Re: Consultation response to Application K/11/22/PL

Thank you for your consultation letter regarding the application for the neighbouring property at 37 Coastal Road. Whilst we have no objection to the principle of a re-build we **do object** to certain features of the application which would impact on our amenity and privacy. These are identified below.

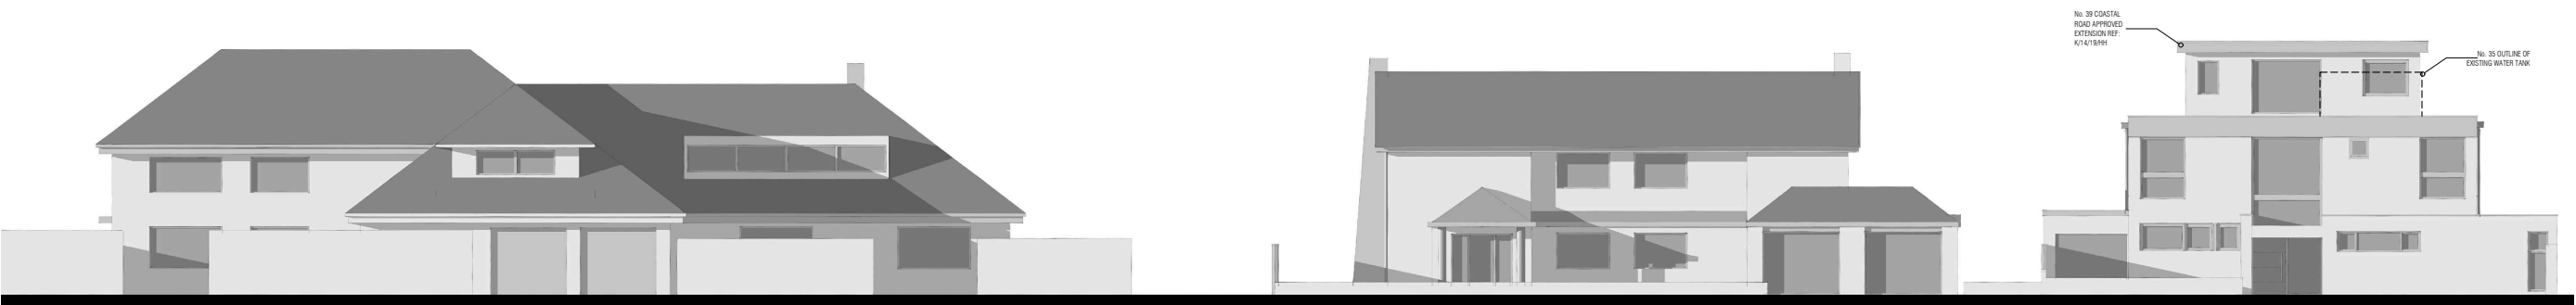
The proposed elevations shown on the drawings P232-110, 109 and 104 do not show these panels on the elevations and the parapets are not deep enough to screen them. The Kingston Parish Neighbourhood Plan, KPNP-7 Design & Development item (viii) suggests that solar panels should sympathetically relate to and be visually integrated, however we will be able to see them from our second-floor terrace as will everyone else from the beach. We also question why this building needs an air conditioning plant on the roof as

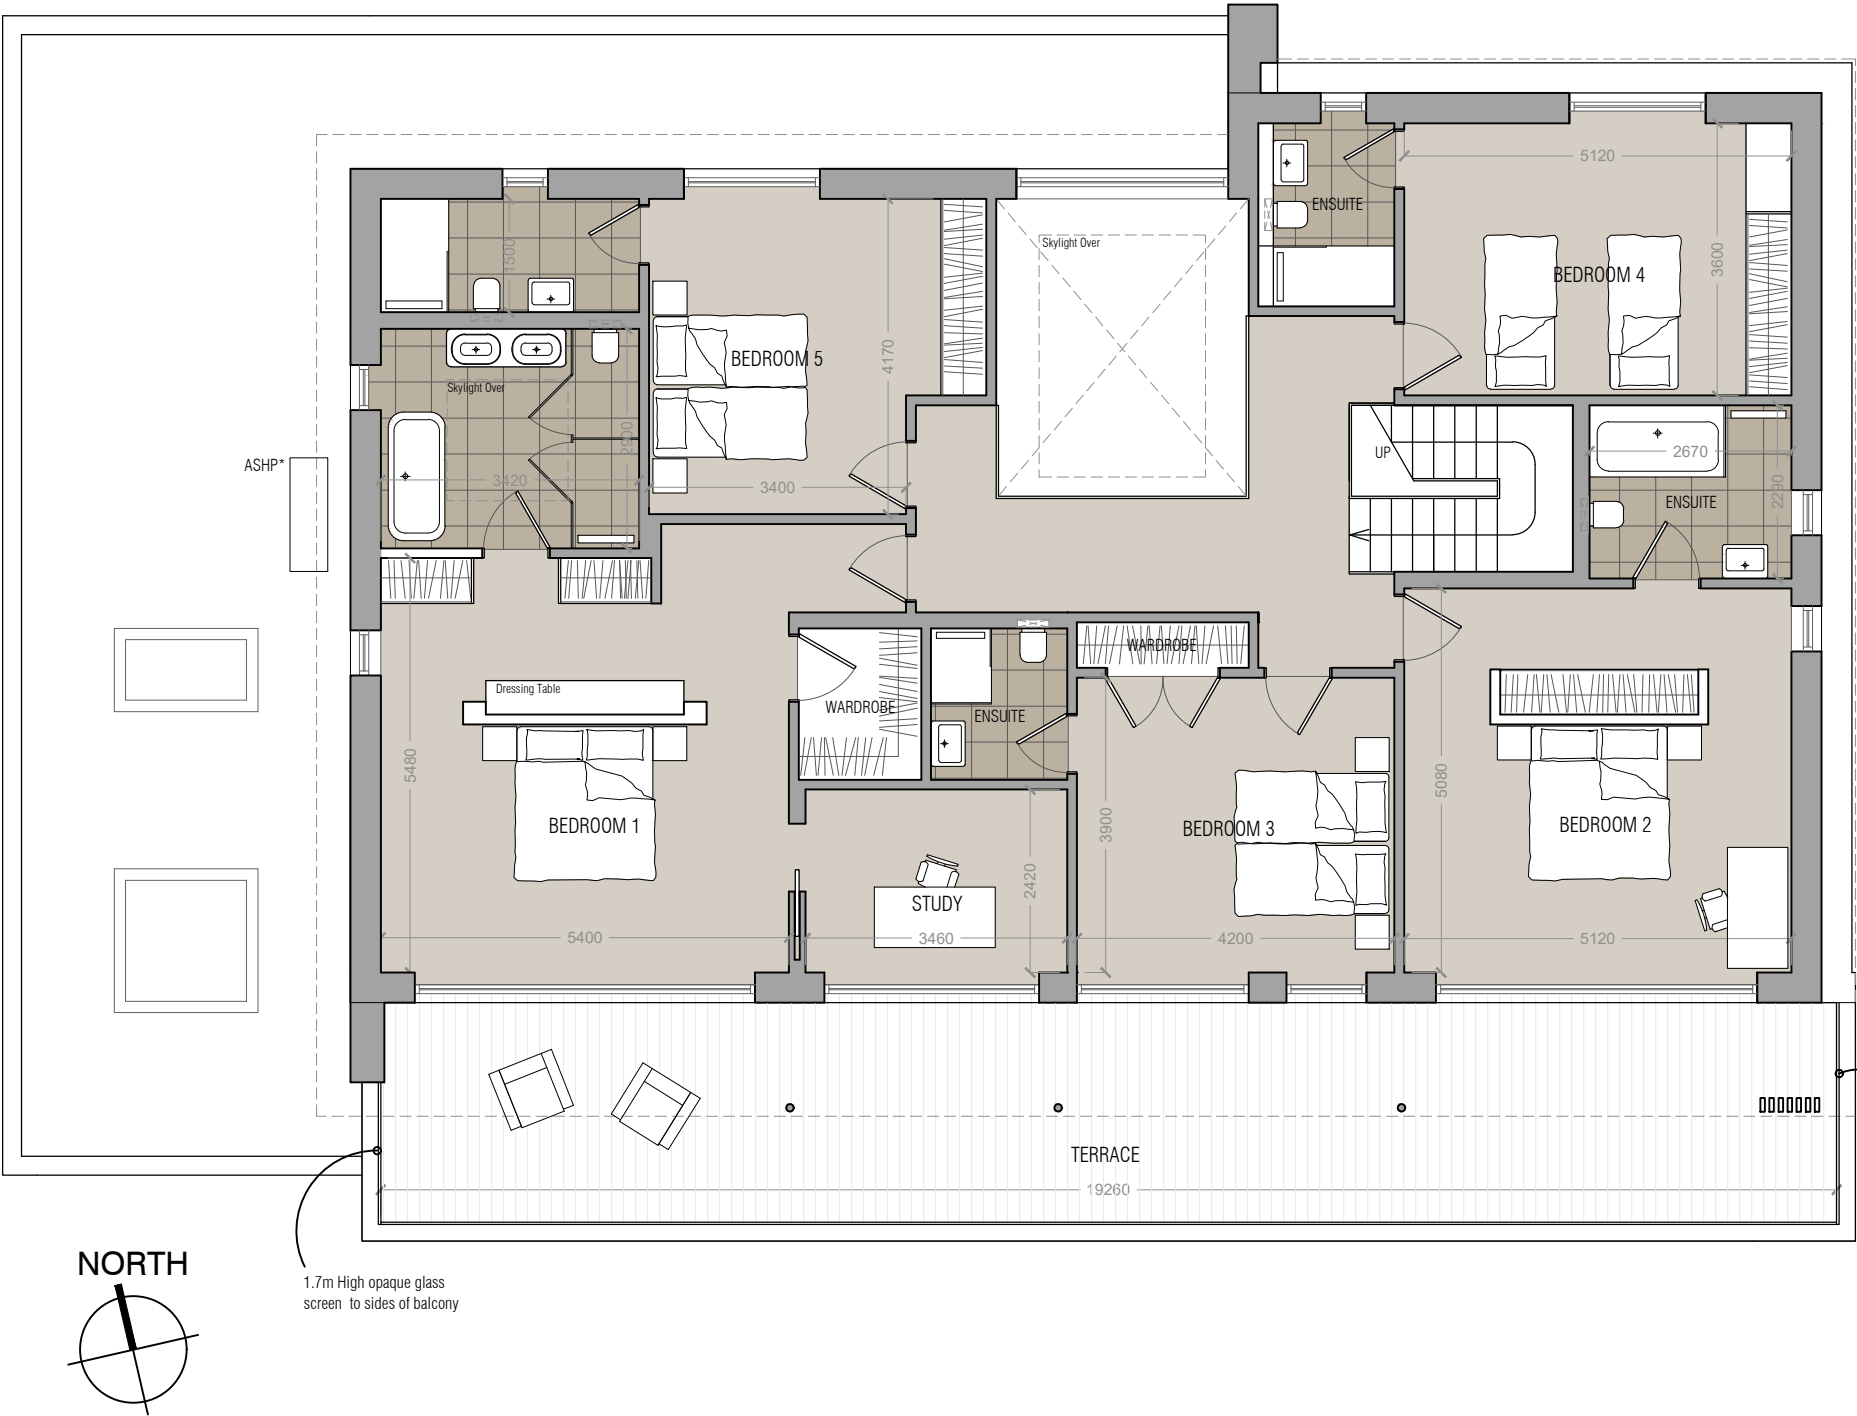
The first is to the first-floor balcony. We believe that a privacy screen should be included to both end of the long balcony to avoid overlooking into our property and gardens terrace immediately outside our rear doors. This was a requirement of our application (K/14/19/HH) which sets a clear precedent for such features.

Whilst it is commendable that the development is looking to be more sustainable and environmentally conscious, we have an issue with the 16 PV panels shown on the roof. These look at least 2m x 1m long and typically have to be at an angle of between 35-60 degrees for maximum effect.

if it is meant to be environmentally friendly, this plant will be noisy and environmentally unfriendly, and if it is to be maintained then it should be appropriately visually and acoustically screened which, like a point raised above would be incongruous to the form of the house. Instead, the use of the relocated pool plant room should be explored for the purposes of air conditioning.
